Application for a non-material amendment following a grant of planning permission.

Number	25
Suffix	
Property name	
Address line 1	Stewards Rise
Address line 2	
Address line 3	
Town/city	Arundel
Postcode	BN18 9ER
Description of site location must be completed if postcode is not known:	
Easting (x)	500611
Northing (y)	106492
Description

Two storey side extension and single storey side/rear extension including demolition of existing garage and summer house.

AB/132/18/HH

Drawing Number	2019/73	Sheet	1 of 2
Size	A1	Scale	1:50, 1:100

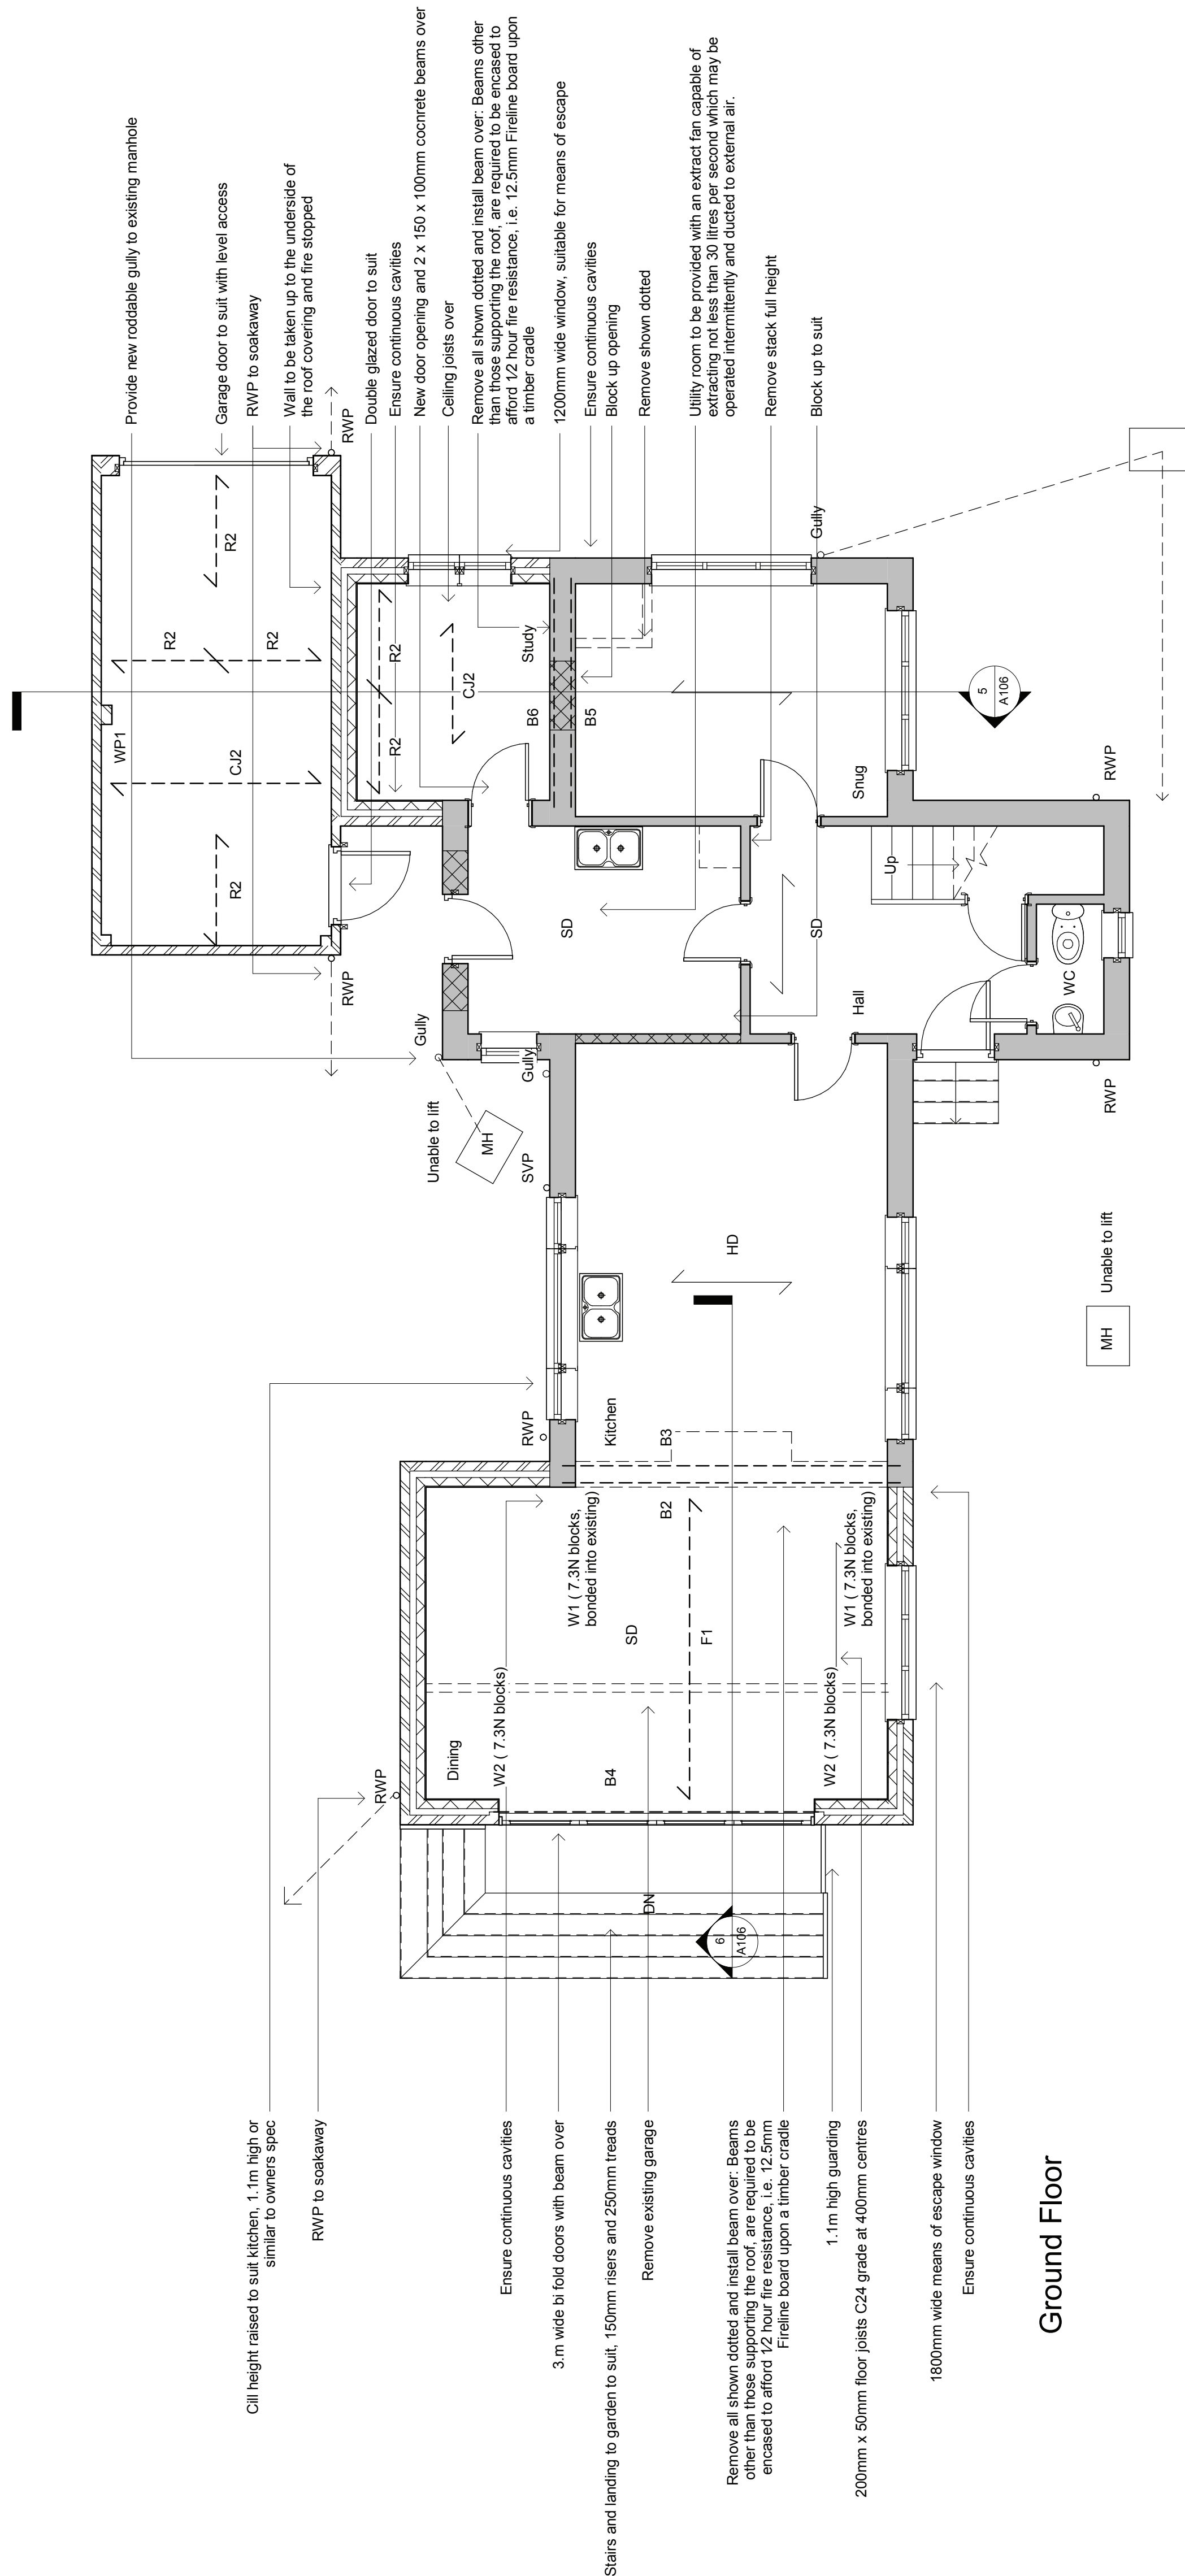
Ground Floor

1. Remove north facing sitting room window to enable Wall-mounted TV.

2. Demolish wall between sitting room and lounge to create open plan kitchen lounge.

3. Reduce height of north facing window in lounge to enable kitchen units to run along that wall.

4. Dining room - replace north window with back door to enable access to garden.

5. Block up wall between dining room and kitchen to create two separate rooms.

6. Create internal door from dining room to kitchen area to access future study.

7. Kitchen - Utilising existing exterior wall block doorway to create 2 separate rooms (snug and study) and remove chimney stack.

8. Lobby - remove west facing door and change east facing door to window.

9. Remove lobby area (unnamed in plan) enabling garage door to open into garden area.

First Floor

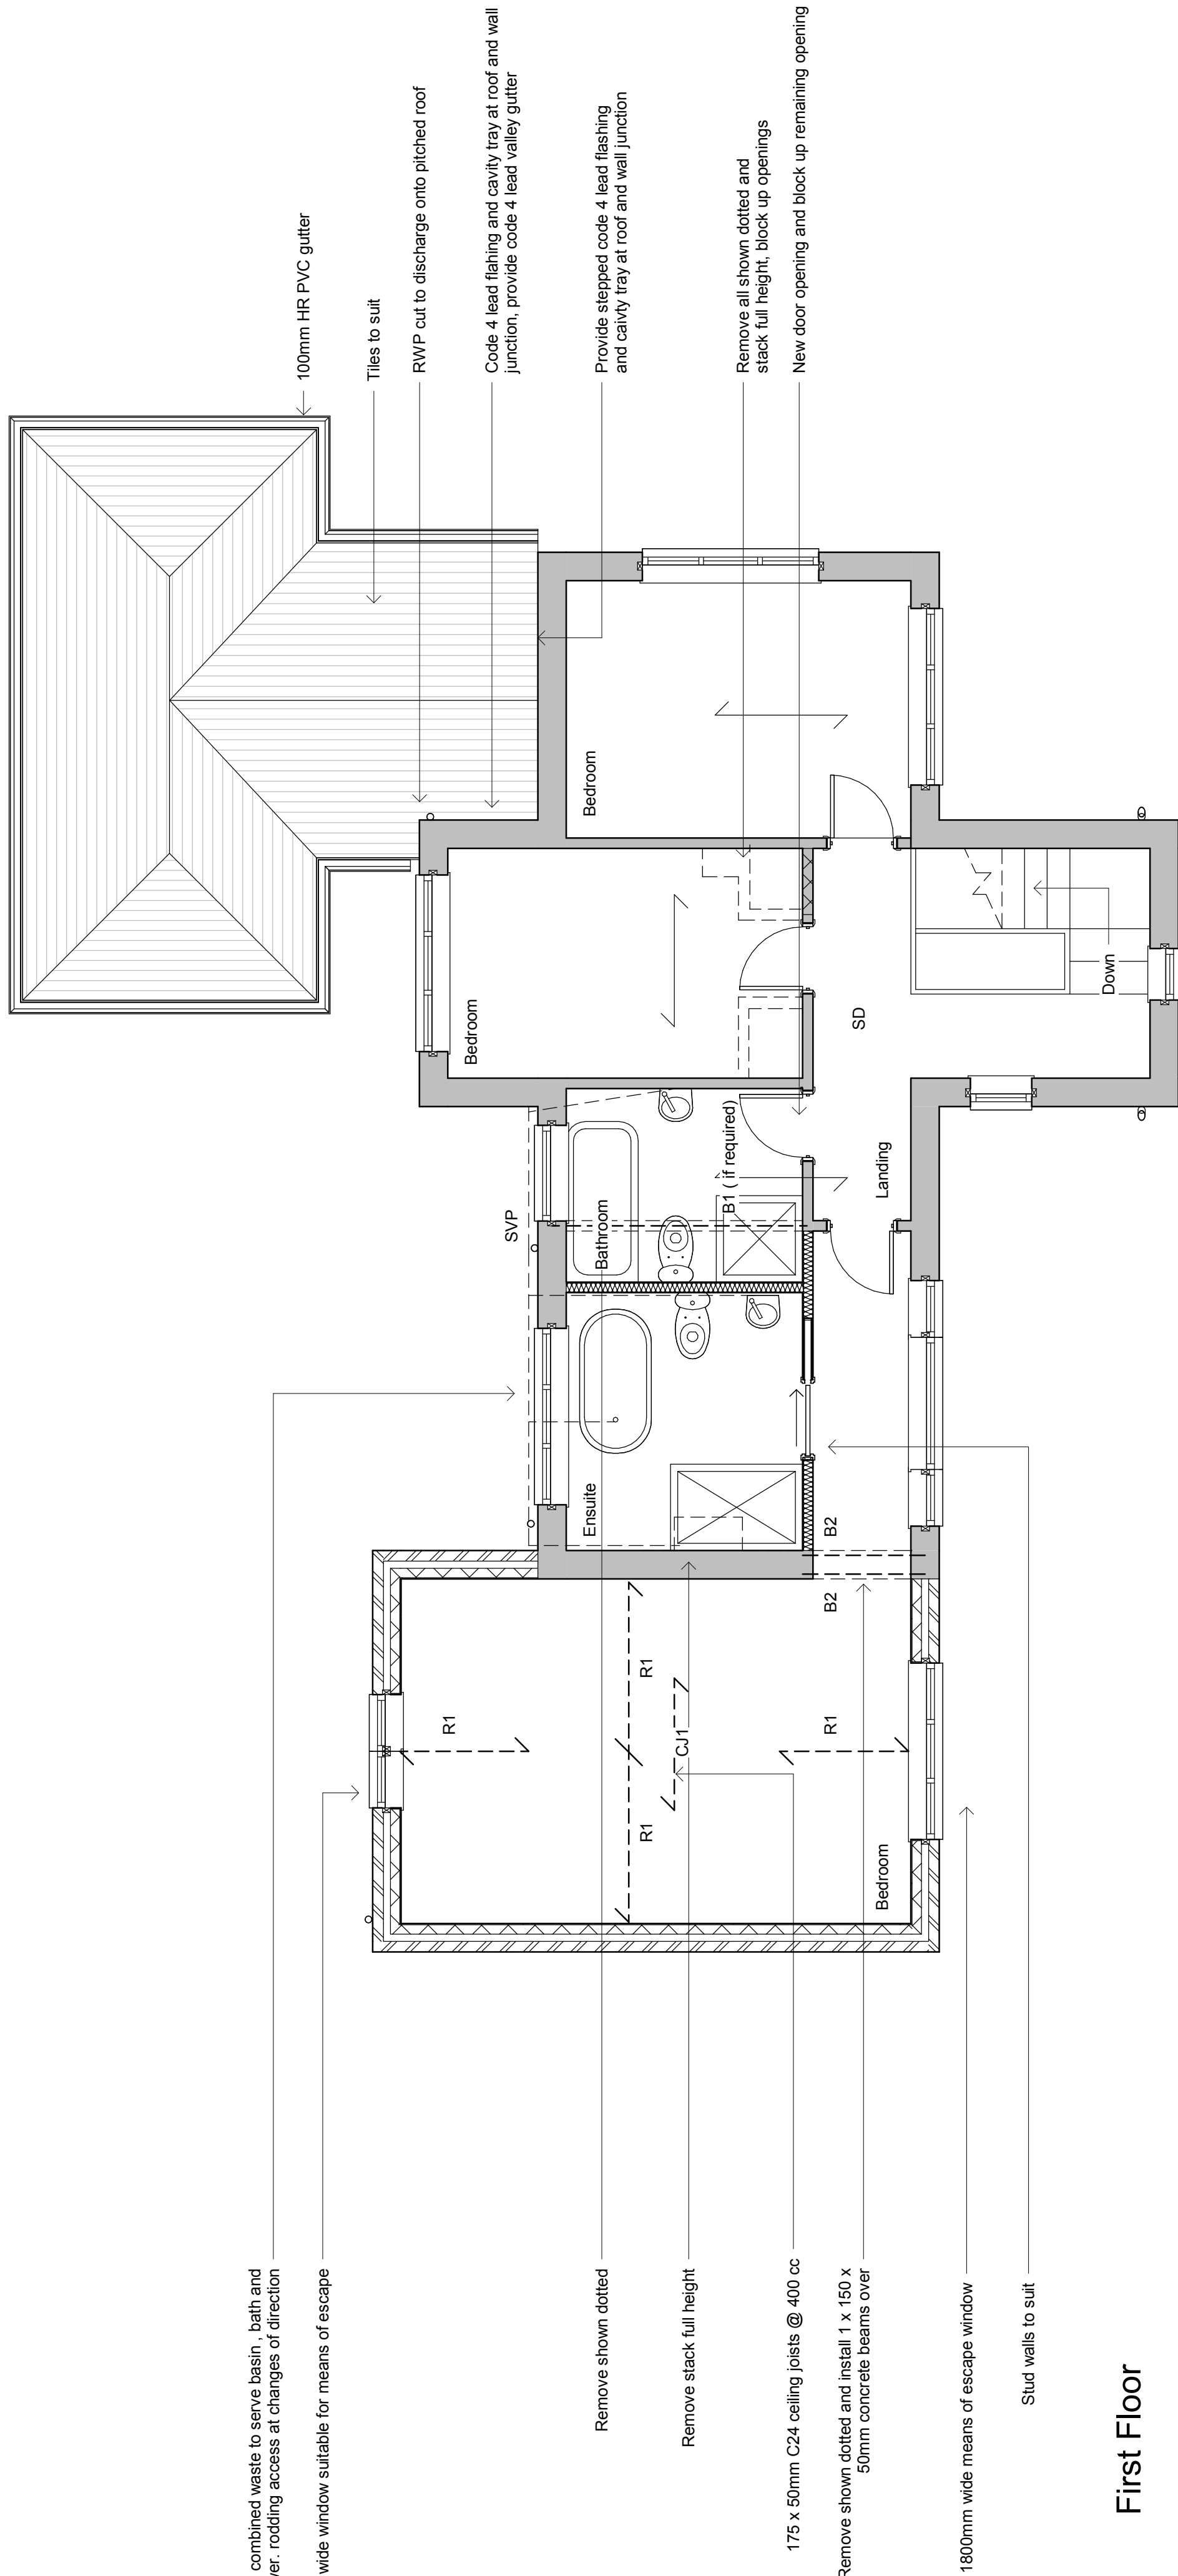
First Floor

1. Bedroom 1 - remove en-suite partition.

2. Bedroom 2 - remove chimney breast.

3. Move wall between Bedroom 2 and Bathroom to create master en-suite and larger family bathroom.

4. Bedroom 1. - remove internal door to landing and move back along landing to create master suite.

5. Bedroom 3 - remove internal cupboard and chimney stack/water tank cupboard.
